MJ & CGM Harding SD
40 Kirklands
Welwyn Garden City
AL8 TRD
8-10-2013

Dear Sir, Council Office Extension N/196/2013/1938/MA.

Title Proposed Materials

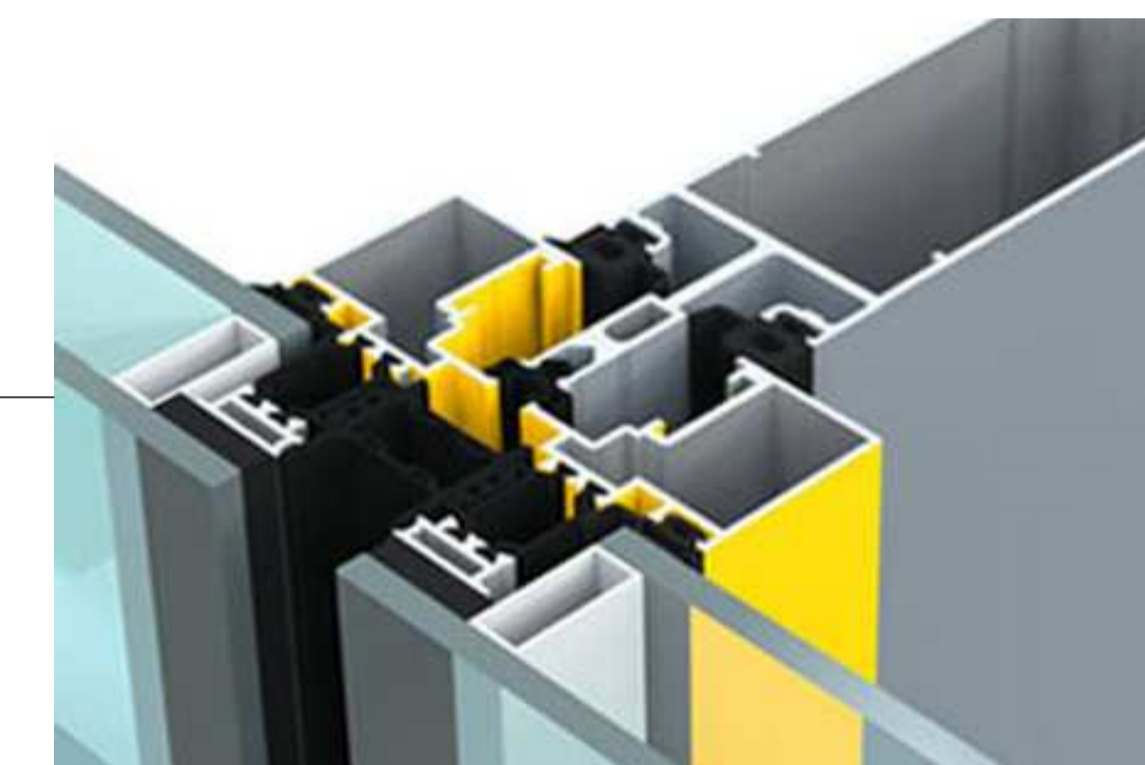
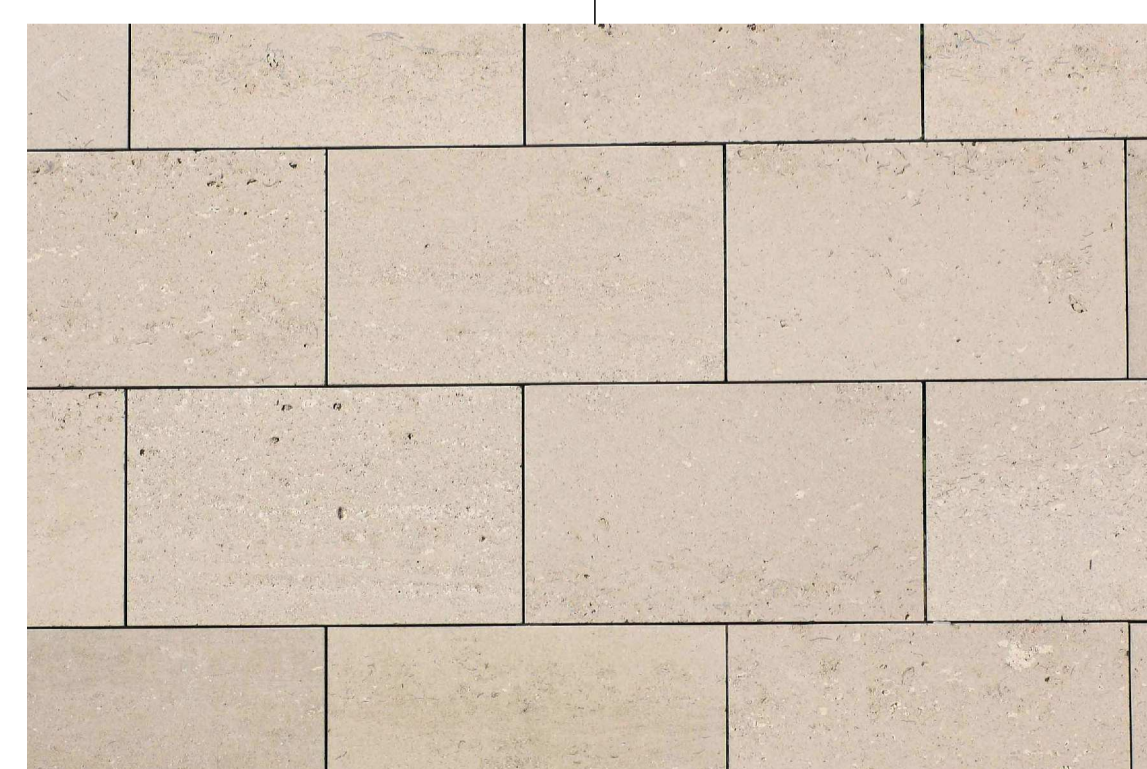
1. The extension does not fit in with the existing building appearance and does not follow the ethos of the Garden City. Whilst the Garden City should encourage modern designs this one is ugly and incorporates too much glass which is out of keeping with the other town buildings. The Council appears to be breaking its own rules on the town development.
